Application No: Y/23/22/HH
Site Address: 1 Tillington Cottages Main Road Yapton BN18 0EU
Description of works: Single storey side extension. This application may affect the character and appearance of the Church Road Conservation Area.

OWPC46408

Ground Floor Plan as Proposed 1:100

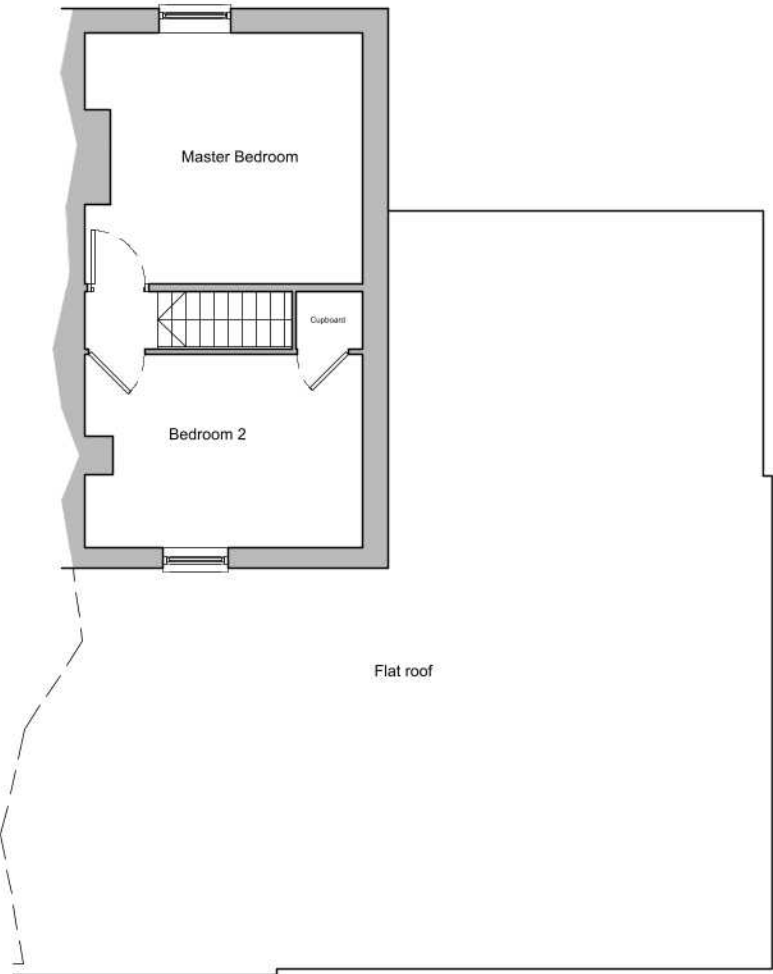
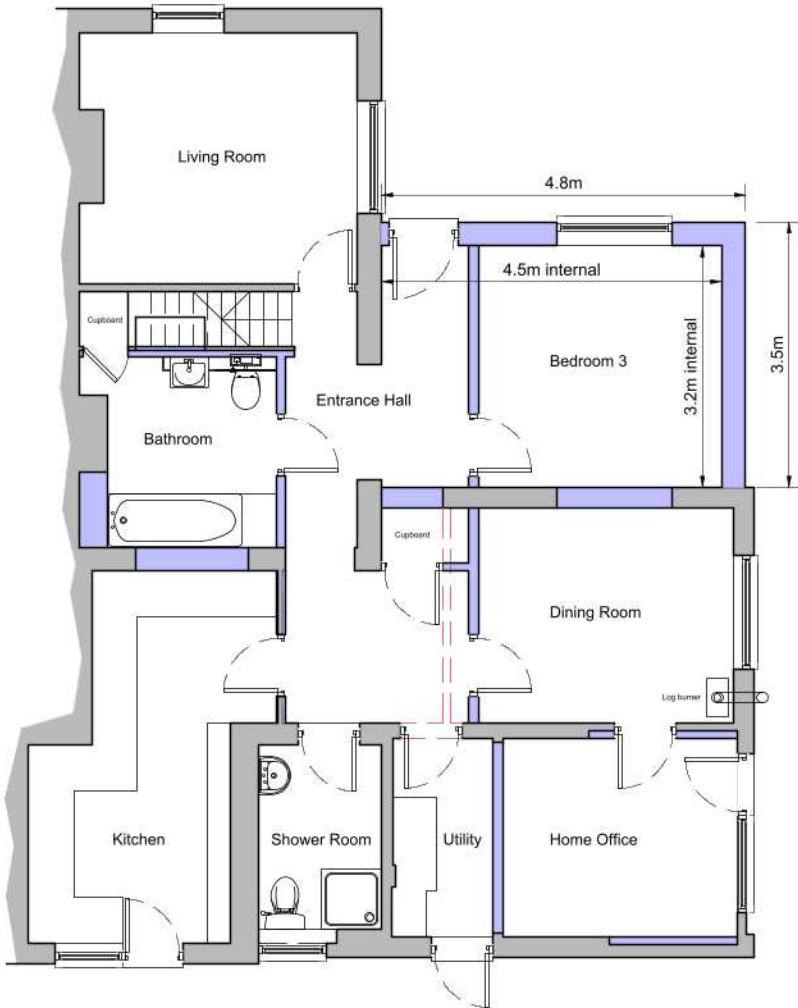
YPC have strong concerns relating to the impact the single storey extension would have on the Main Road street scene. YPC would like to see a more sympathetic design in terms of materials and the Main Road elevation to ensure an enhancement of the conservation area.
